Having attended and now having discussed the recent Issue Specific Hearings, Honingham Parish Council wish to make the following additional submission.

Figure 3.2 – Proposed Wood Lane Interchange

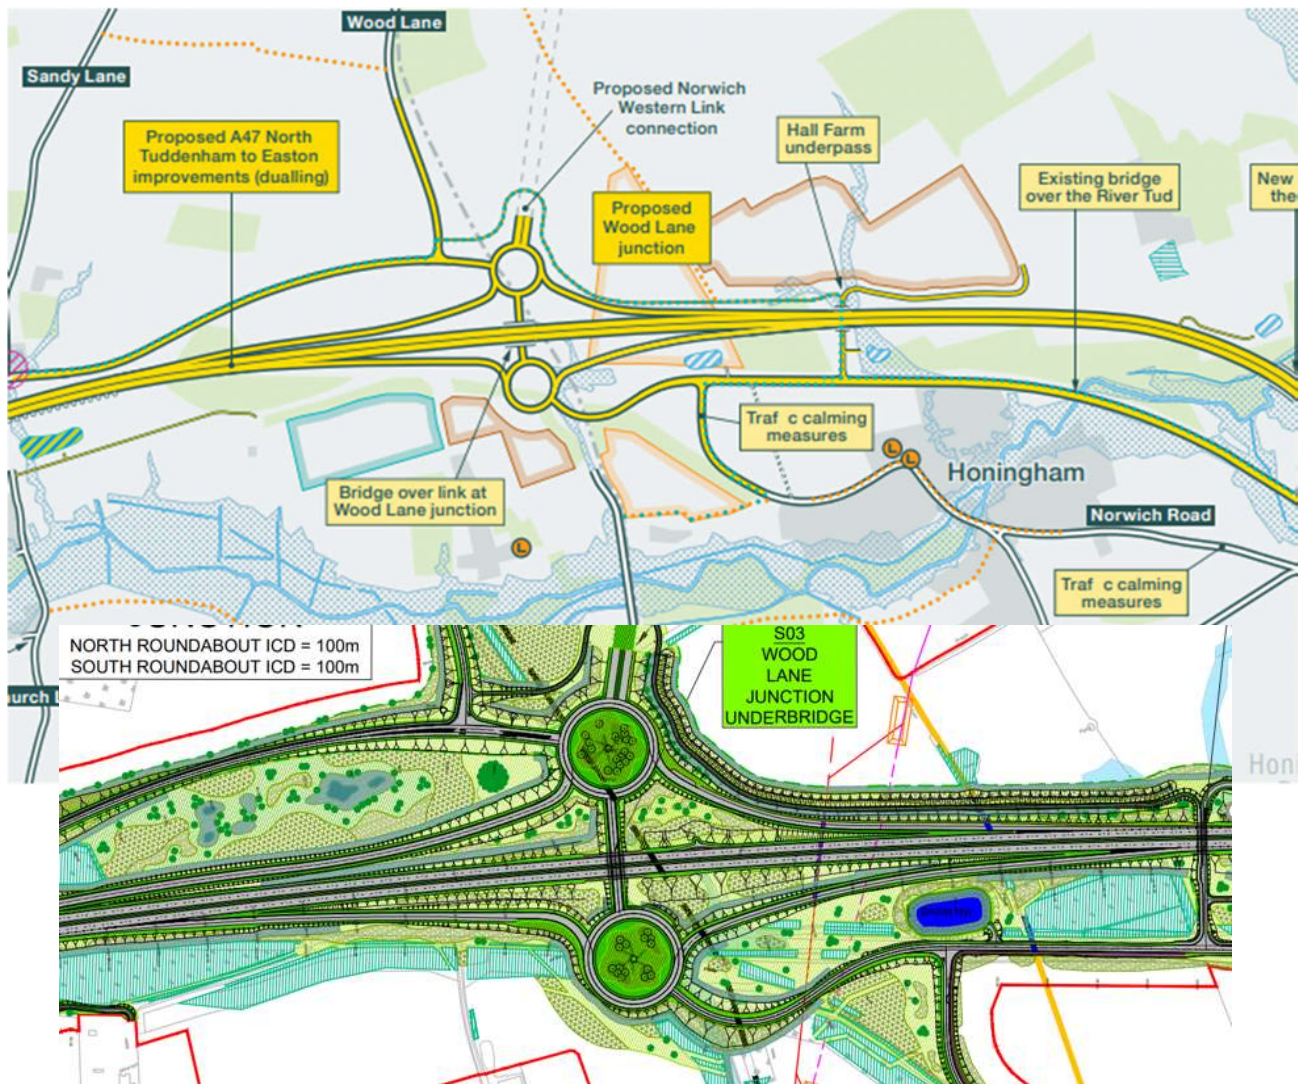
The Council supports the Berry Hall proposed alternative plans in respect of the Wood Lane/NWL junction. This shows that it is potentially feasible to design a junction that significantly reduces existing mature tree and hedgerow removal required in the current scheme. This would provide significant immediate environmental gain in a world where climate change and conservation should now be overriding priorities. In our view the current scheme 15-year environmental net neutral target does not sufficiently recognise this priority. This alternative would also provide for increased mitigation to shelter the west side of Honingham from what will be significant visual, noise, pollution and light impacts on local residents. This alternative also keeps open more of the existing A47 (via the Lady's Grove underpass) which provides advantages in terms of a direct route for local bus services (potential services from Hockering - Honingham - Easton and onto Norwich), local motorised traffic and cyclists – all of whom would not need to negotiate the proposed Wood Lane / NWL A47 mainline junction. The size of the over designed roundabouts on the current National Highways proposals at this junction remain a further key concern. It appears that the designed capacity to have minimal queues in 2040 based on historically informed estimates of future journey growth (before current trends to work more from home and be more sustainable can be effectively determined) and to provide a link to the NWL that may never be built is at the needless expense of considerable immediate environmental damage. The existing junction proposal may meet required regulations and design standards but, in our view, completely misses the opportunity to considerably reduce environmental damage and to maintain connectivity of the local road network.
